Submission ID: 5933

Schedule 1, p6. Page 44 of the 167 page document posted on 12 October, Works No.47. HE appears to refer to taking control on Taverham Road for 270m north of the Tud bridge, but the HE drawings only outline the road up to the entrance to Church farm House - which is barely 20m north of the bridge. (270m beyond the bridge would take their works some way up past our own property - for what purpose?).

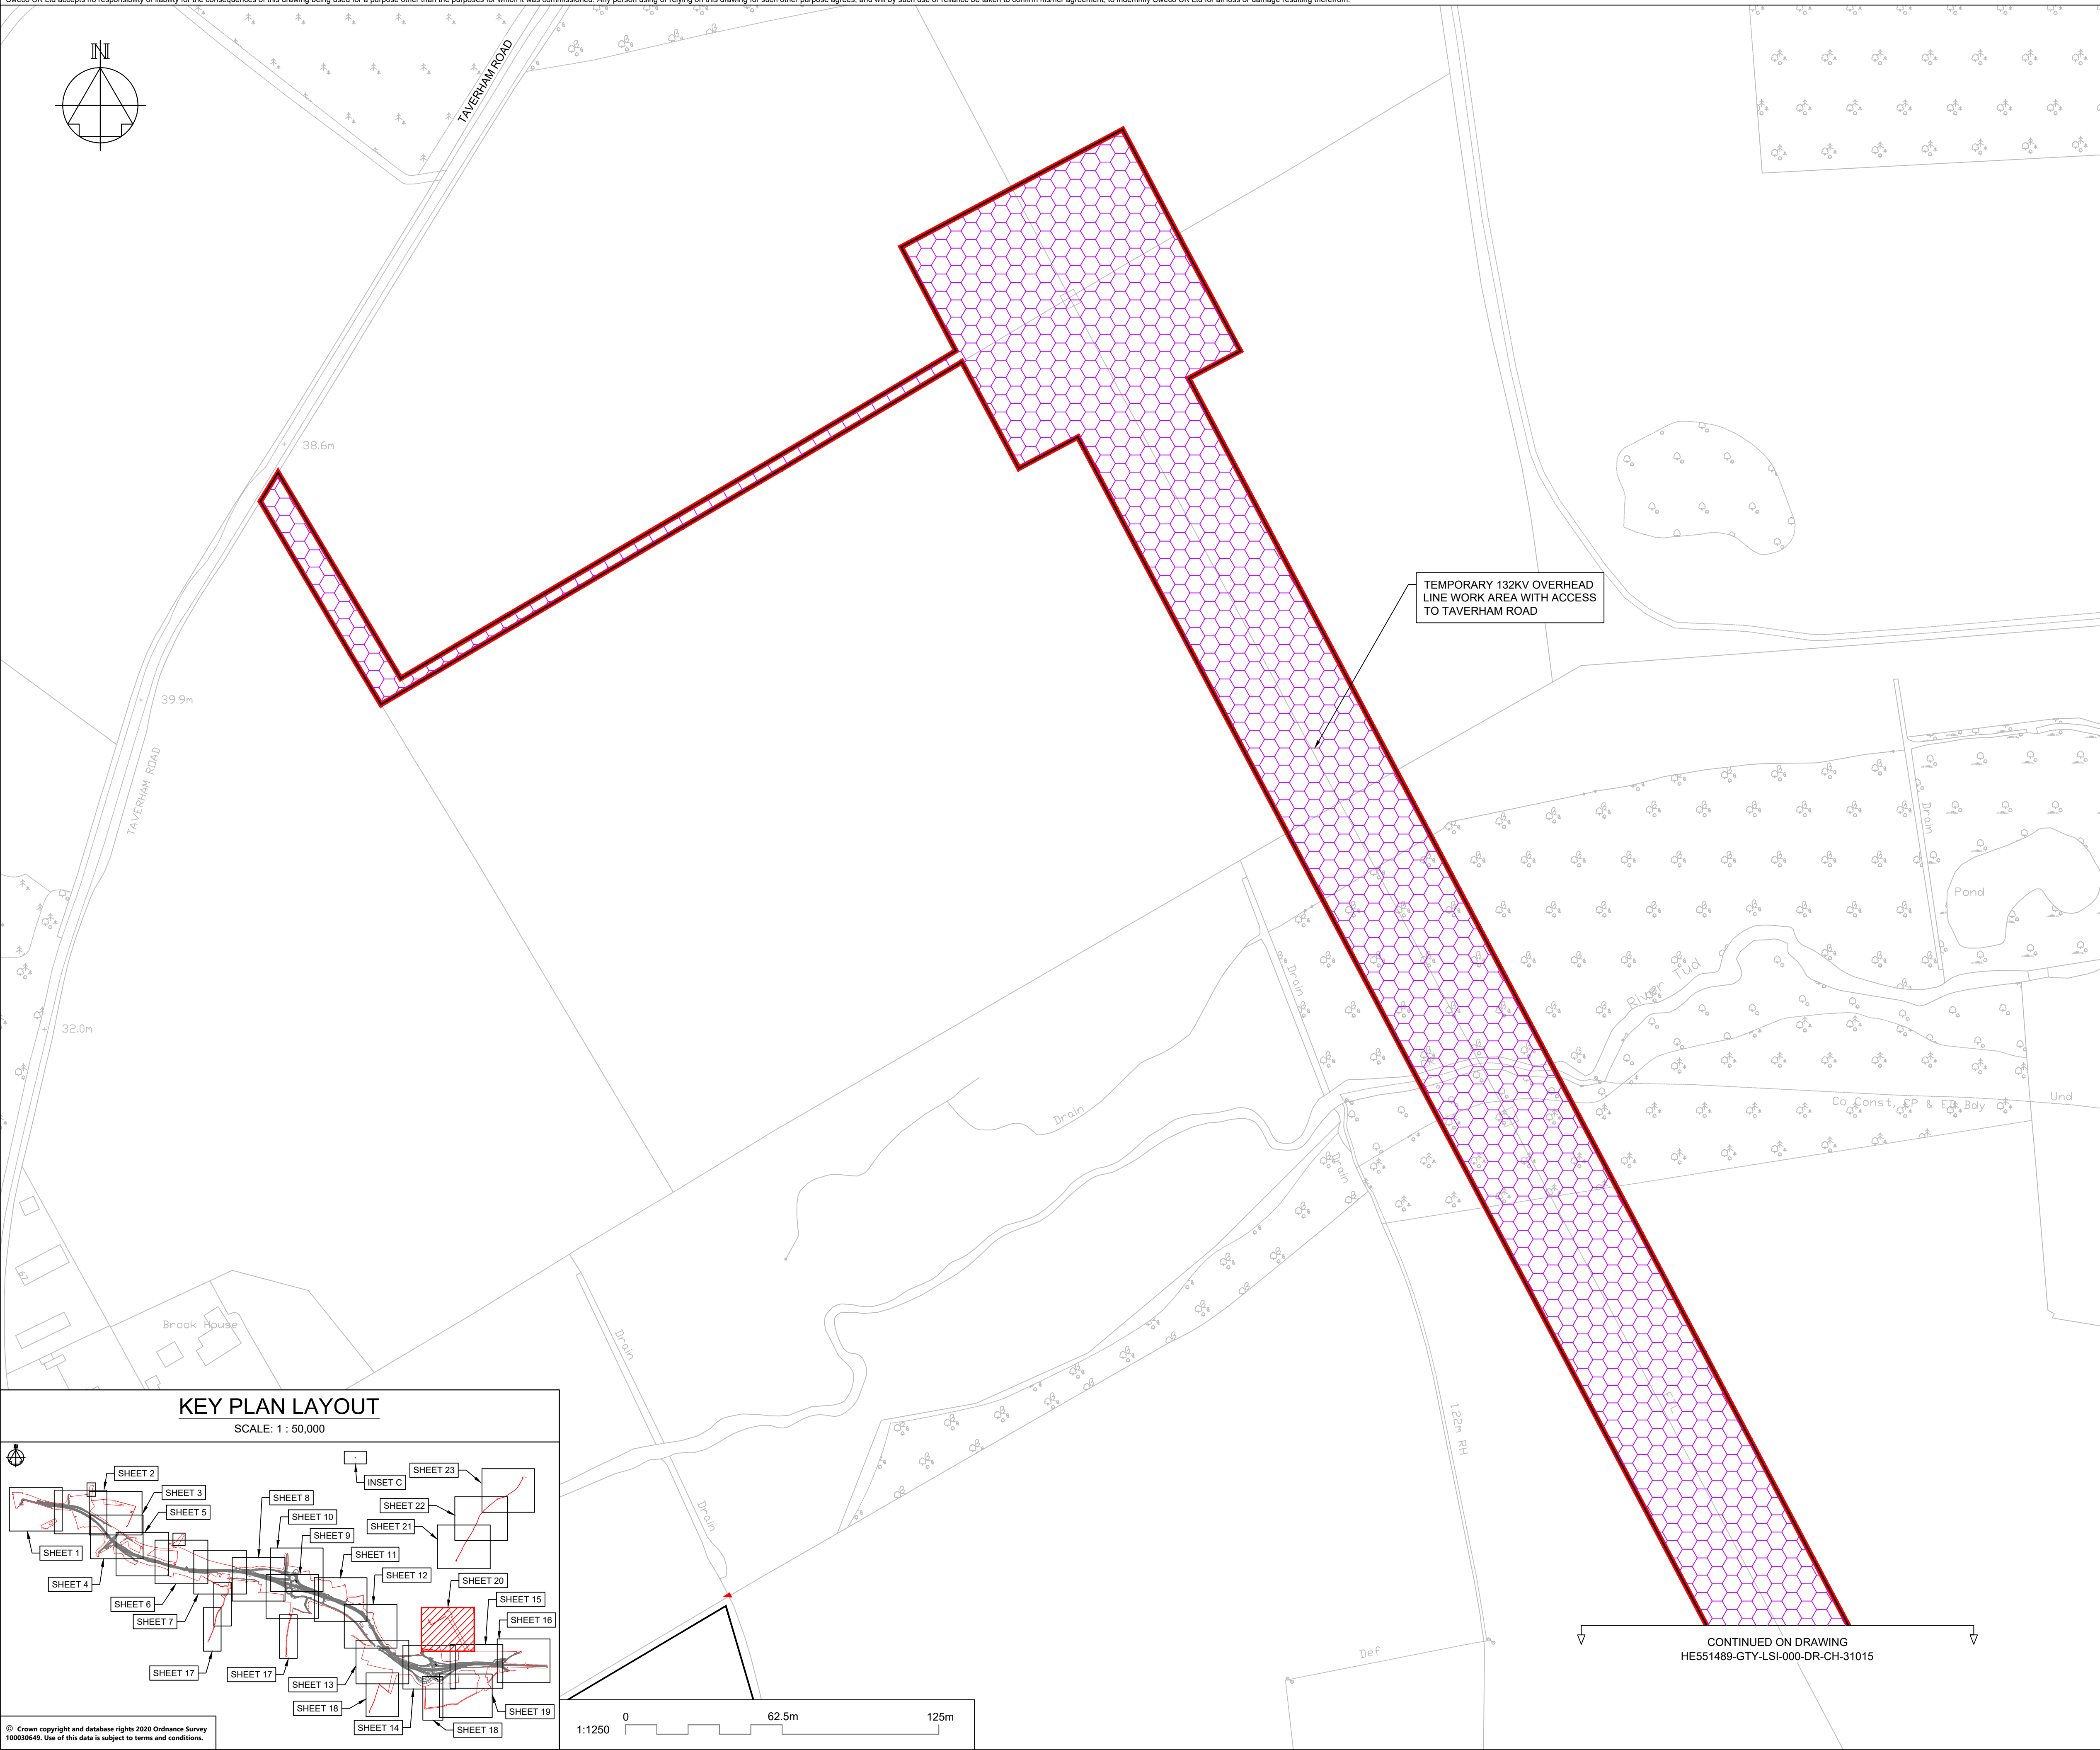
Notwithstanding my original Statement submission, I have noticed an apparent and worrying discrepancy between HE's text in their draft consent and their drawings. I would request that this be checked / queried by the Inspectorate and clarified by HE - and the text corrected as appropriate.
